**KIRKLEES METROPOLITAN COUNCIL
INVESTMENT & REGENERATION SERVICE**

DELEGATED DECISION TO DETERMINE PLANNING APPLICATIONS

Reference No: 2021/62/92936/W

Site Address: 54, Greave Road, Hade Edge, Holmfirth, HD9 2AQ

DRAWING TITLE: GA as Proposed Option 1

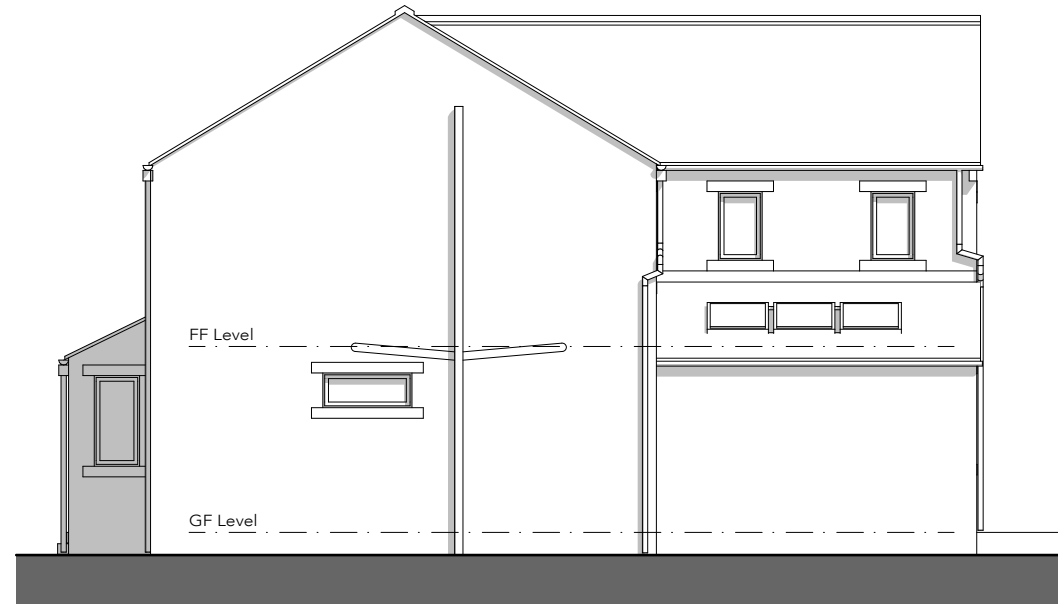
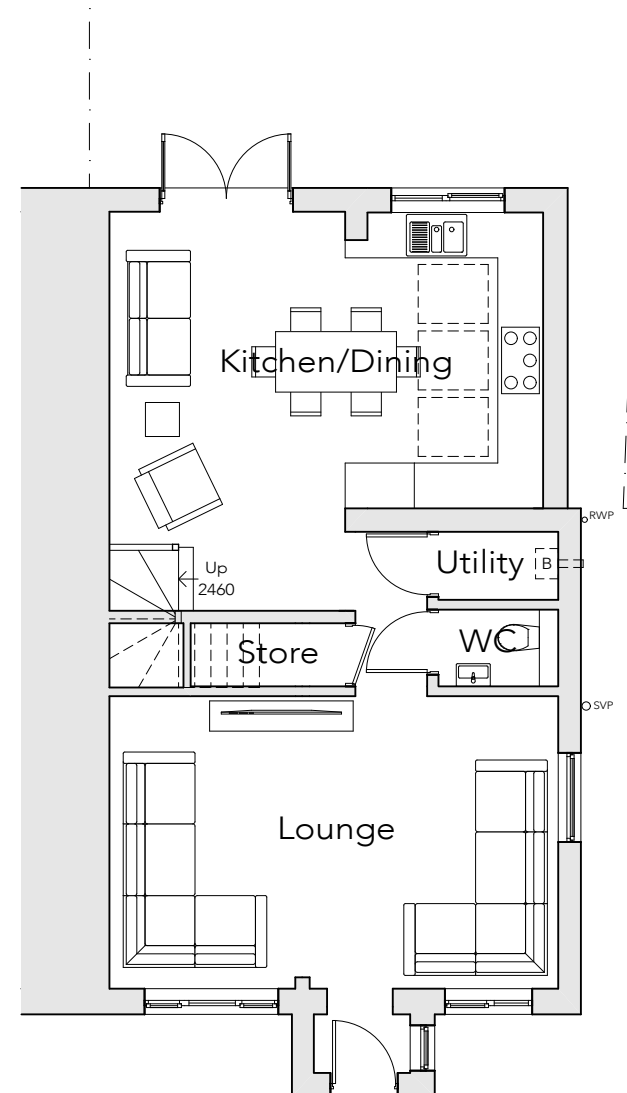
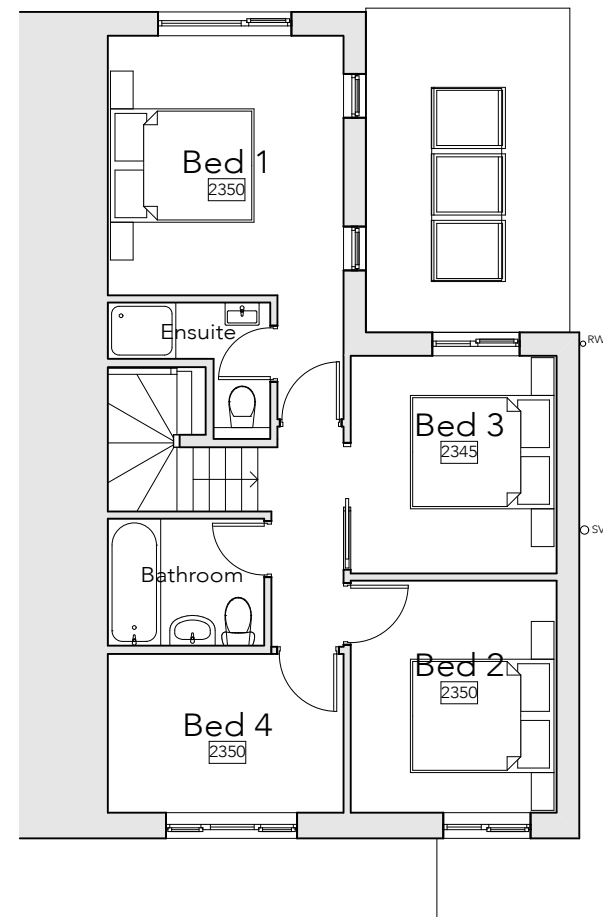
The proposal originally stated 'demolition of existing conservatory, erection of single storey side extension, first floor rear balcony and exterior alterations' however, amendments were sought by the case officer to remove the balcony. This is because, although the other proposed developments are acceptable in principle, the balcony was not – posing detriment to residential amenity in terms of neighbouring privacy and overlooking and resultantly, failing to comply with LP24 of the Kirklees Local Plan and Chapter 12 of the National Planning Policy Framework. It should also be noted that the proposed balcony failed to meet the requirements of a balcony development as outlined in the council's House Extensions and Alterations SPD (June 2021).

Further amendments were also sought regarding the proposed additional window to be erected in the western side elevation at first floor level, serving an interior bedroom. The case officer communicated with the applicant

requesting that this window become obscurely glazed, for reasons of residential amenity.

Amended plans were submitted by the agent, removing the balcony and showing only the proposed single storey side extension and other more minor exterior alterations to the host dwelling. These revised plans have been used to assess and determine development at 54 Greave Road.

Upon submitted amended plans, the applicant removed the window from the development scheme. Therefore, it was no longer necessary to consider this window within the assessment or determination of this application.
